WEST SUSSEX COUNTY COUNCIL CONSULTATION

TO:	Arun District Council FAO: Michael Eastham
FROM:	WSCC - Highway Authority: Public Rights of Way
DATE:	02nd December 2020
LOCATION:	Land South of Ford Lane east of North End Road Yapton Arundel BN18 0DS
SUBJECT:	Y/131/20/DOC Approval of details reserved by condition imposed under ref APP/C3810/W/17/3170059 (Y/80/16/OUT) relating to Condition Nos 7 - means of access/egress onto Ford Lane, 8 - retention & improvement of Public Rights of Way 357, 358, 359 & new cycle & pedestrian routes, 9 - Stage 1 Road Safety Audit, 12 - Travel Plan and 17 - Phase 1 Habitat Survey
DATE OF SITE VISIT:	n/a
RECOMMENDATION:	Advice
S106 CONTRIBUTION TOTAL:	n/a

1. Condition 8 (retention and improvement to Public Rights of Way 357, 358 and 359 and new cycle and pedestrian routes)

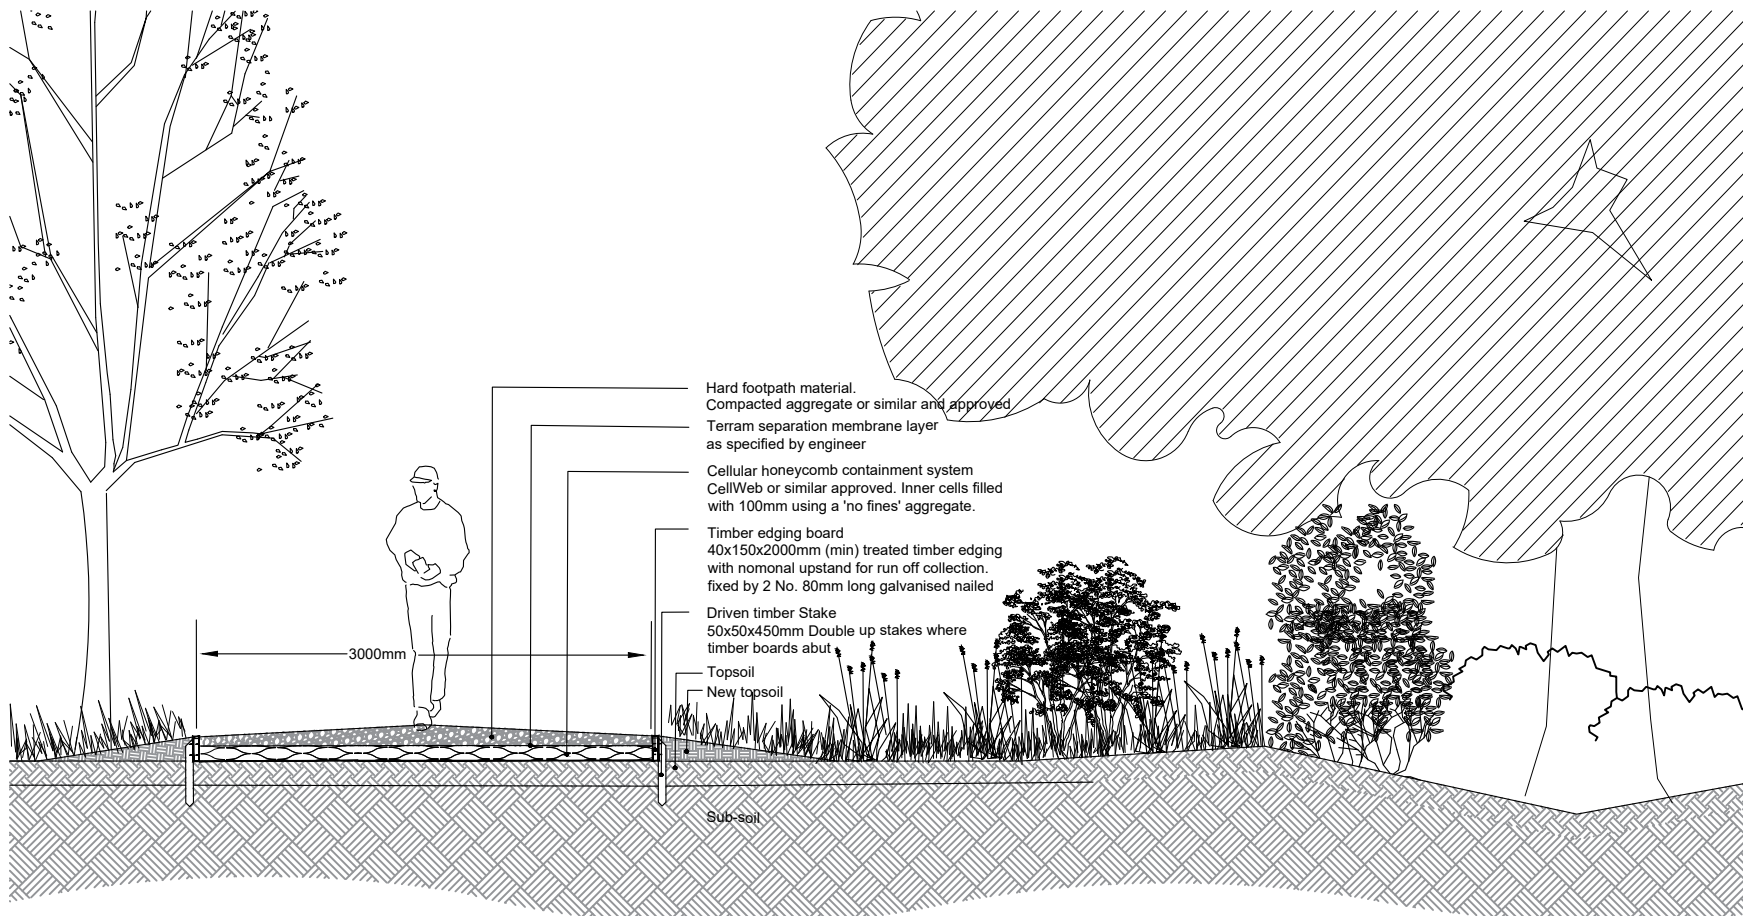
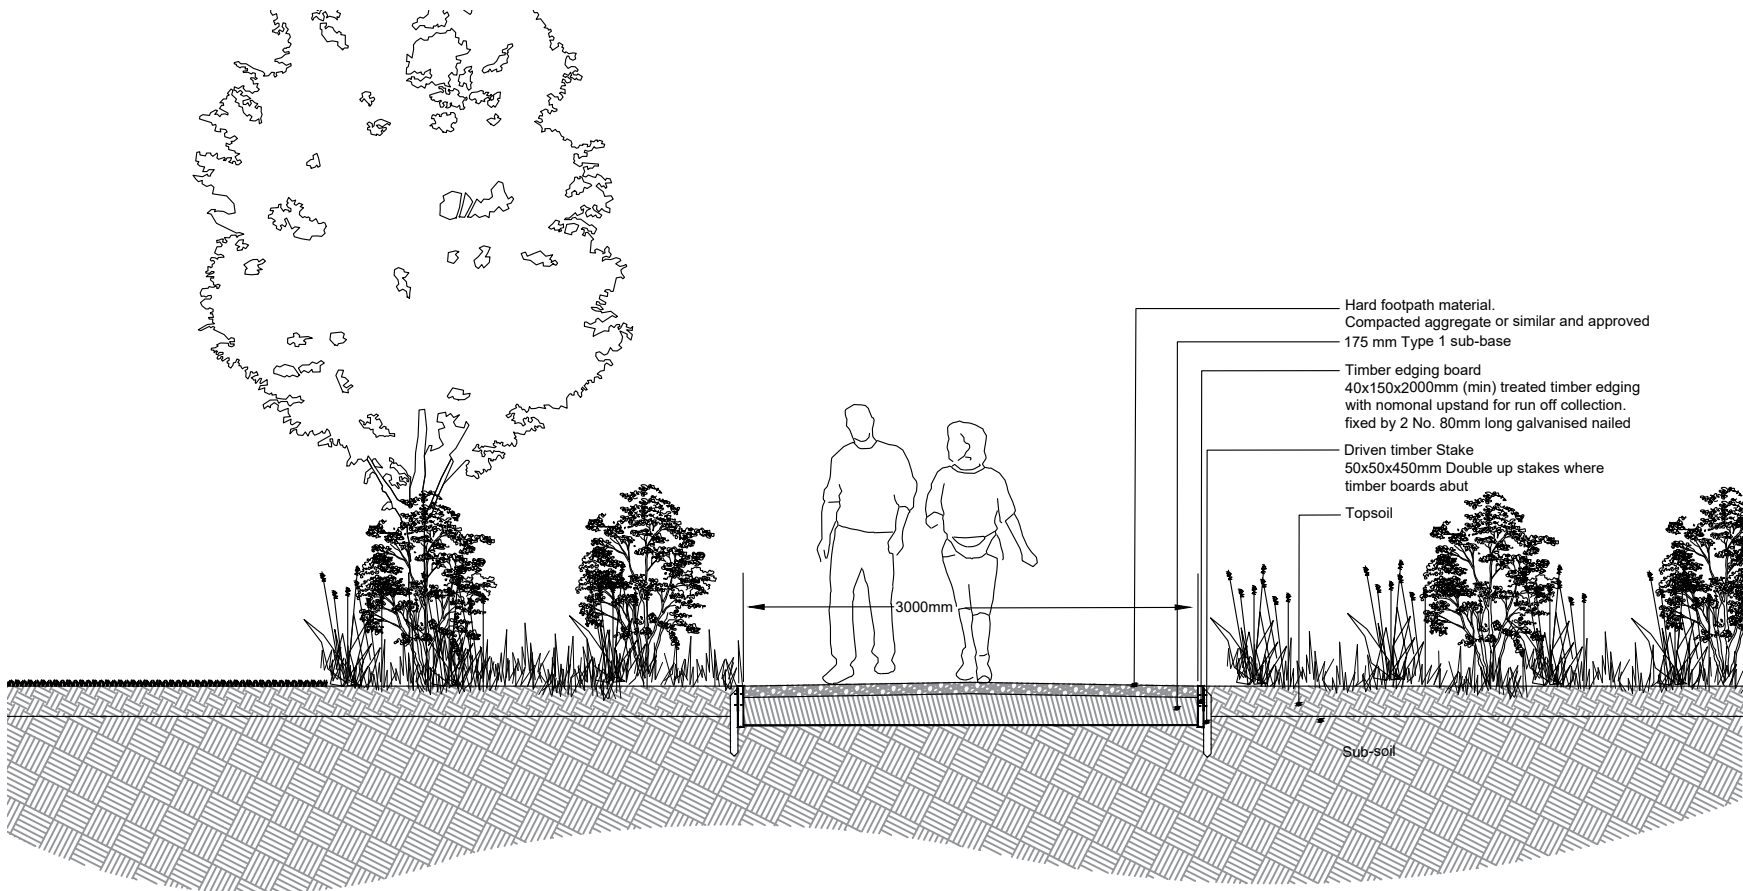
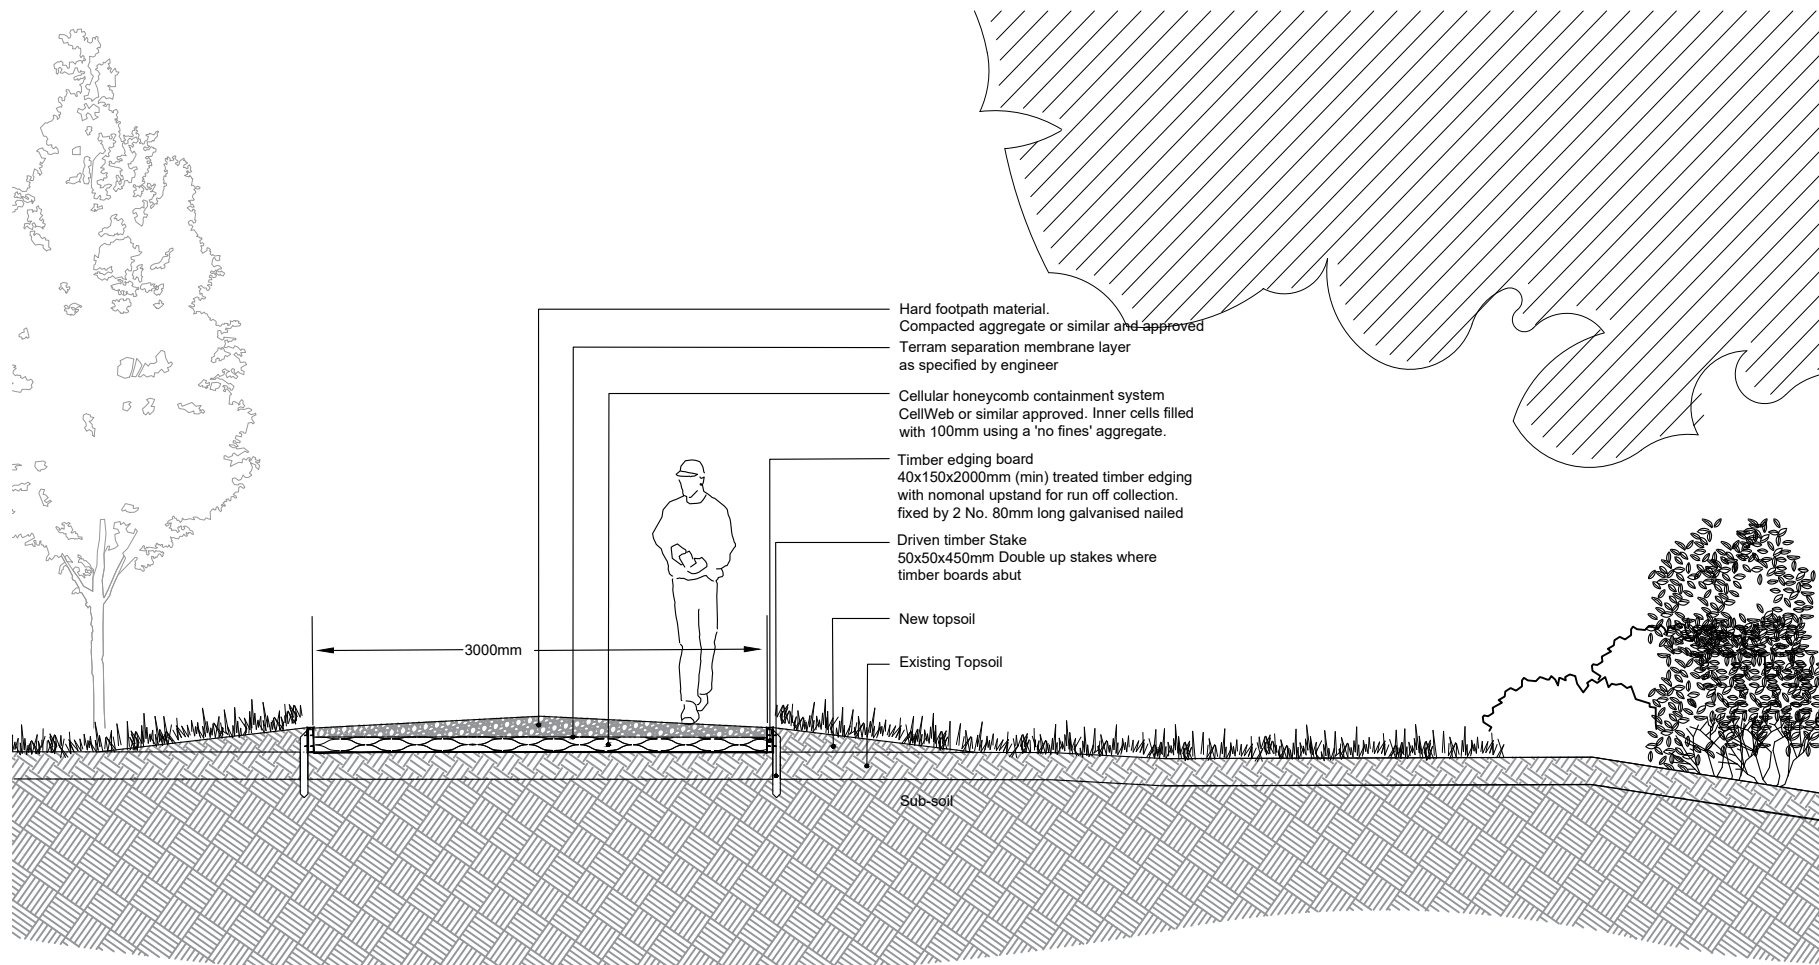
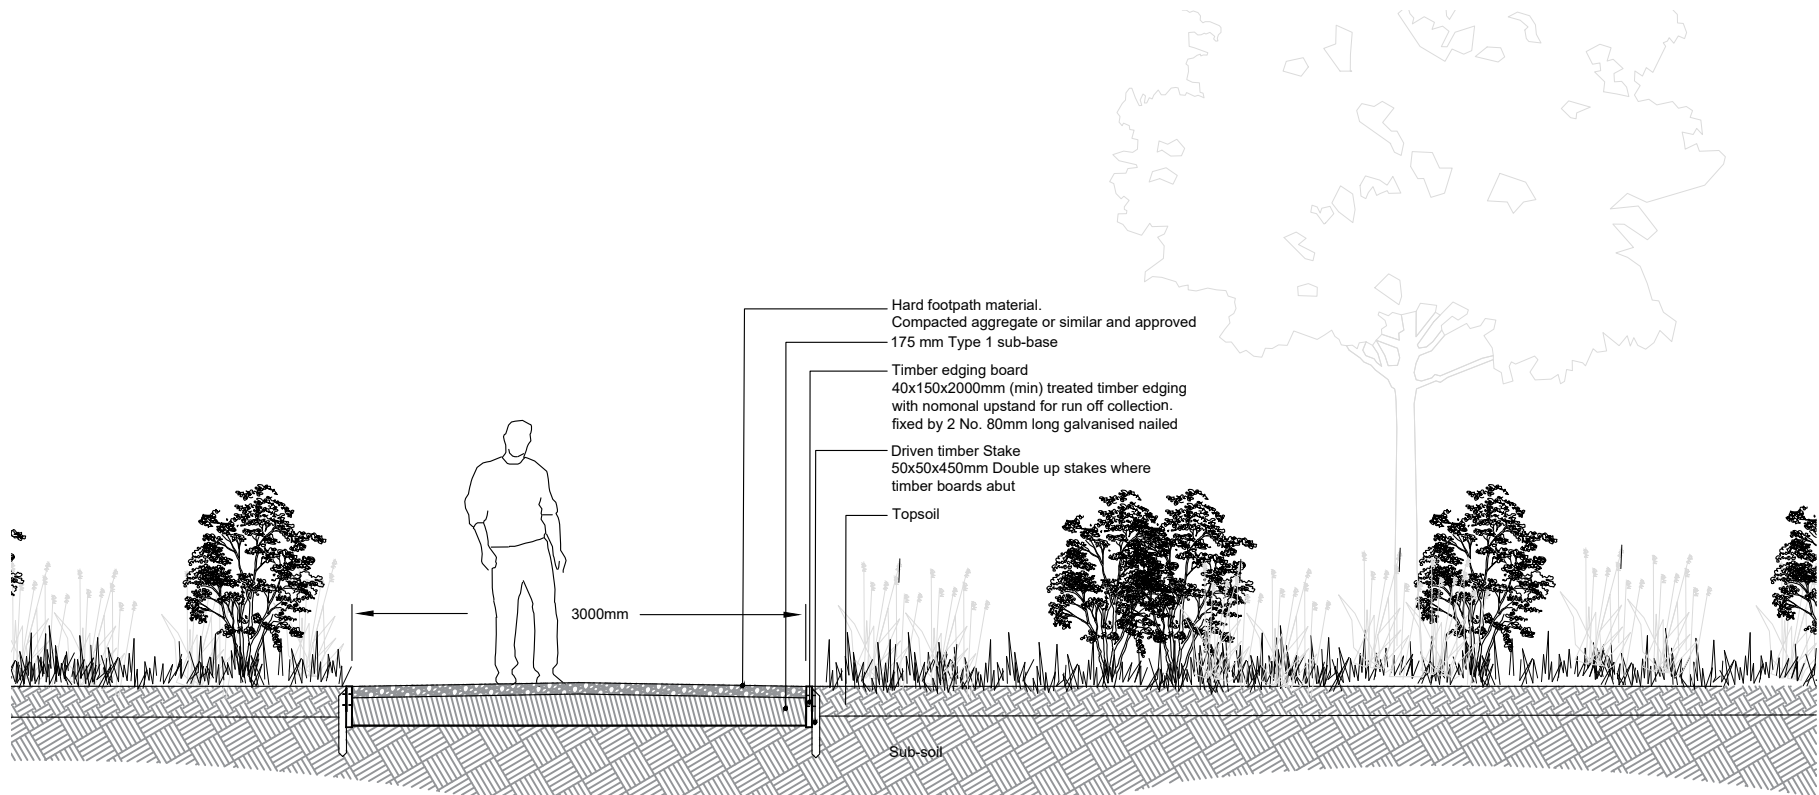
Whilst some discussion has already taken place with regards to FP358 and its dedication to Bridleway status, I would echo the thoughts of Tim Townsend, Principle Transport Planner, WSCC, in his seeking of increased access rights over FP357 across the site also.

An alternative, were the planning authority only to agree upon FP358 being dedicated as Bridleway along the Eastern boundary, as already discussed, would be to formalise permissive cycling rights along FP357. This would ensure flexibility for residents of the development and those accessing the site and remove the potential for conflict in the future where cyclists may well use these routes despite their Footpath status.

Should both routes be formally dedicated as Bridleways we would seek 3m minimum width and surfacing as per our specification which will require specific materials to meet equestrian needs. If FP357 is to allow cycling and pedestrian access only, the surfacing material will not need this specific type but can be agreed in due course. It will however still require a minimum of 3m to ensure safe separation between cyclists and pedestrians.
